**SEA LINK DCO APPLICATION (EN020026)**

**SCC ADDITIONAL RELEVANT REPRESENTATION**

Document 9.3.3 Suffolk Section Phase 2B Archaeological Evaluation Report Extract illustrating the location of the henge in relation to the proposed scheme

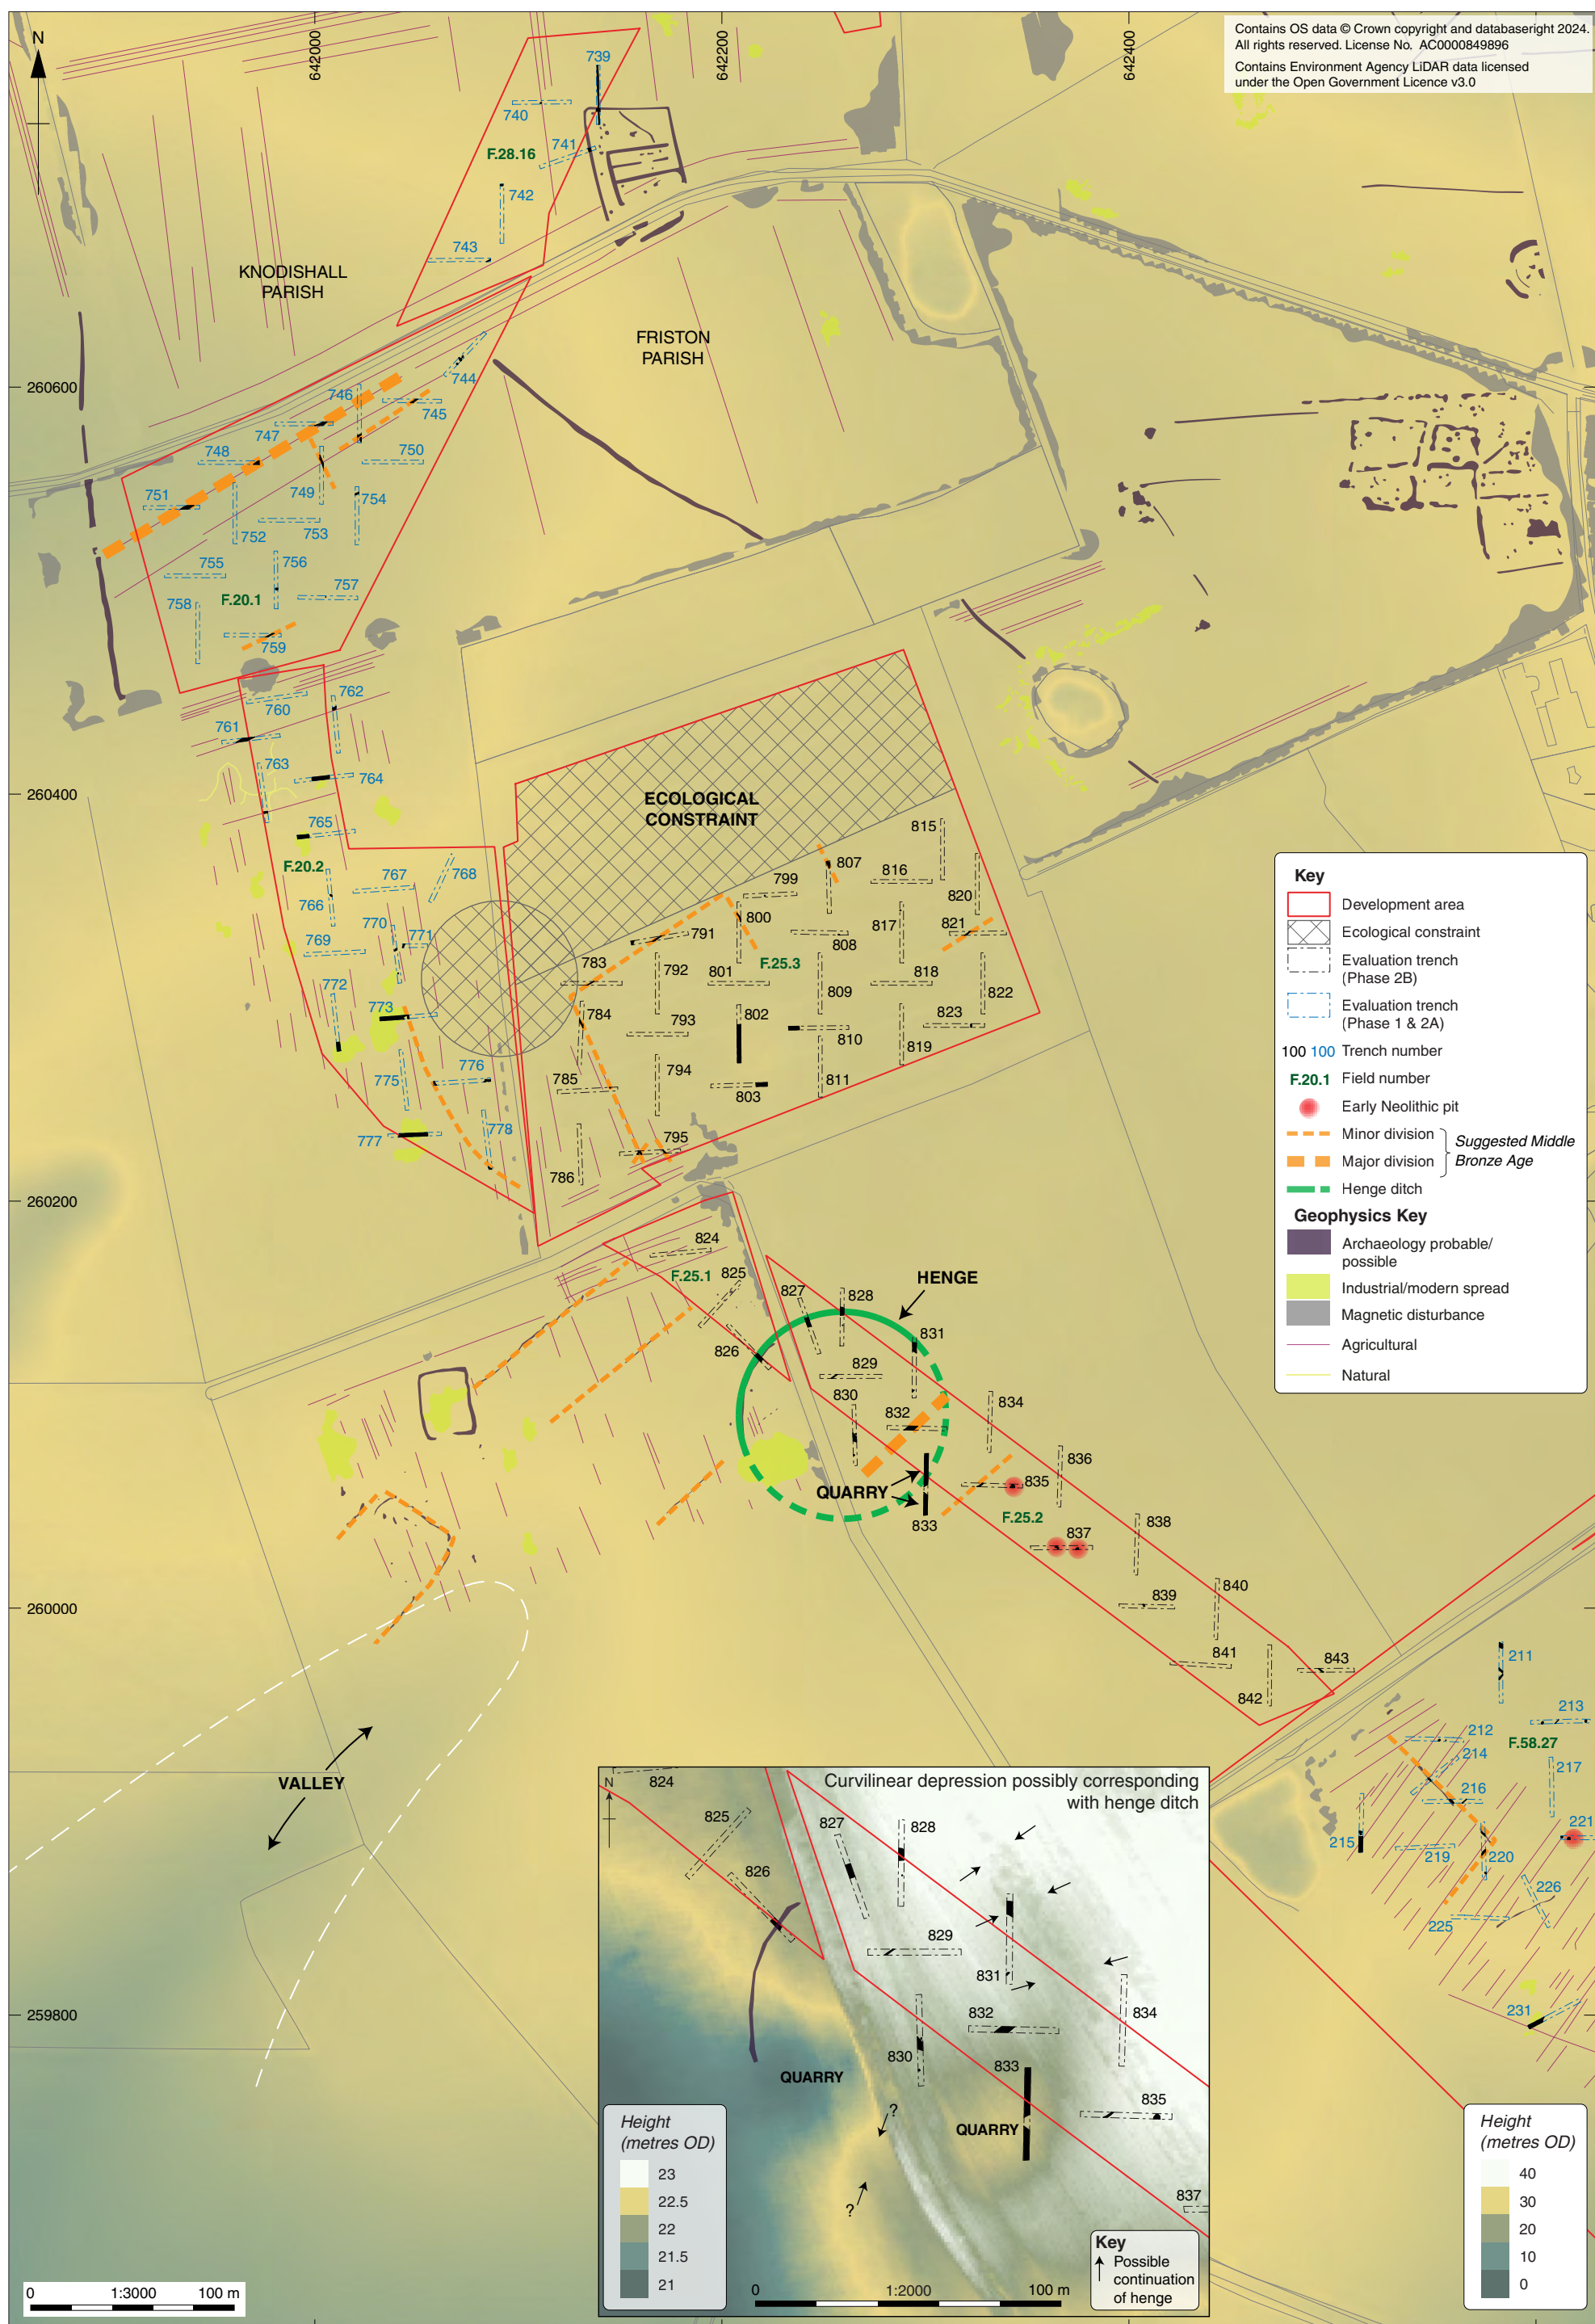
Due to its significance, preservation in situ is considered by Historic England and Suffolk County Council as the only appropriate way to manage this site. Within submitted plans, the proposed cable corridor runs through the centre of this monument and therefore Suffolk County Council and Historic England advise that the applicant should be required to consider alternatives to the current route in this part of the scheme, in order to appropriately mitigate against impacts to this significant heritage asset. Historic England and Suffolk County Council would not, however, consider directionally drilling beneath the monument as acceptable mitigation given the potential risk for negative impacts to occur.

The immediate areas surrounding this monument have not, however, been subject to archaeological evaluation and will therefore need including in the scope of ongoing archaeological geophysical survey and trial trenched assessment work. Appropriate provision will need to be made to mitigate any additional areas of archaeological significance which are defined during archaeological evaluation. Should additional remains relating to the henge monument be recorded during these works, the area requiring Preservation in Situ has the potential to be increased. As such, undertaking archaeological evaluation to find a suitable alternative route should be undertaken at the earliest opportunity within the examination process and prior to the end of the examination period, so that the results of this work can be factored into the design and decision-making process in order to appropriately safeguard important heritage assets.
